FOURSQUARE AT STERLING RANCH PUDSP

LETTER OF INTENT

JUNE 2022, NOVEMBER 2022

TYPICAL ACCESS EASEMENT
SCALE: 1" = 20'

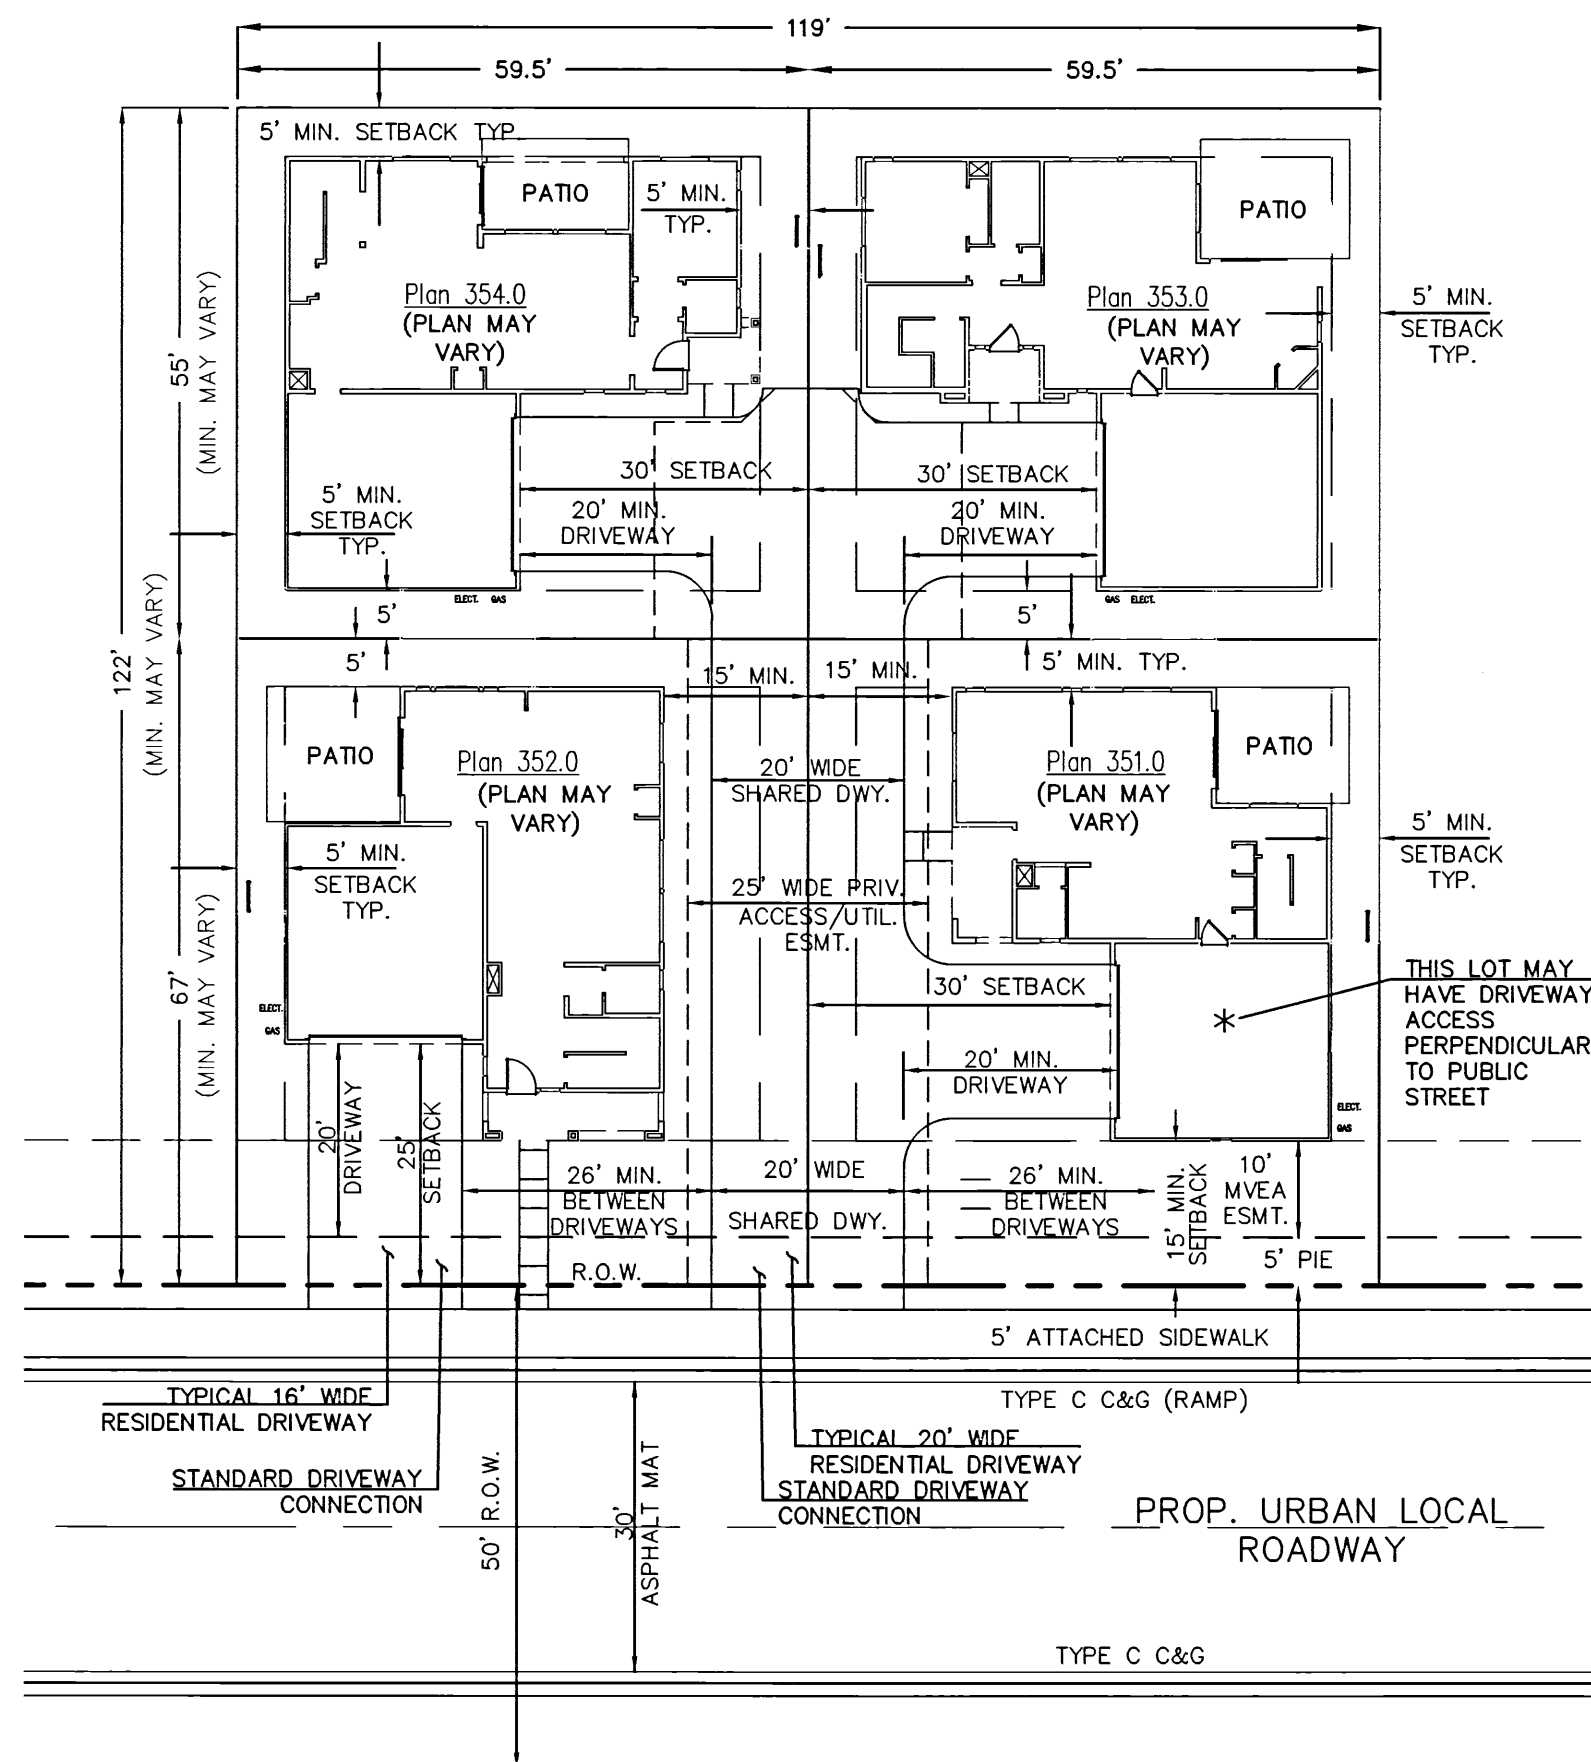
Will there be designated no-parking areas for the trash pickup and delivery vehicles? show on plan.

6' CONCRETE PANEL WALL
SCALE: N.T.S.

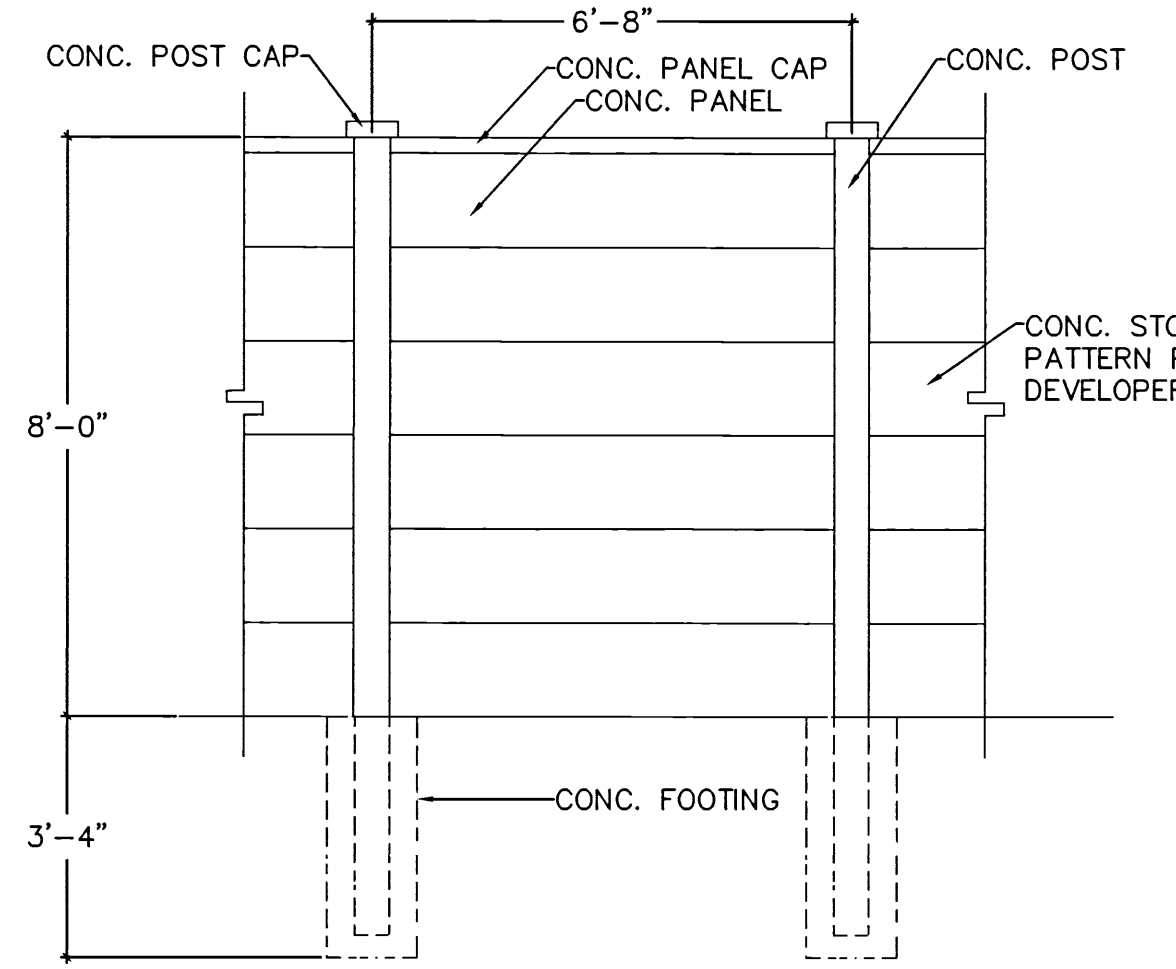
because the distance of homestead to this development, the same study was utilized and the same mitigation is proposed, noisewall ...staff didnt waive the requirement
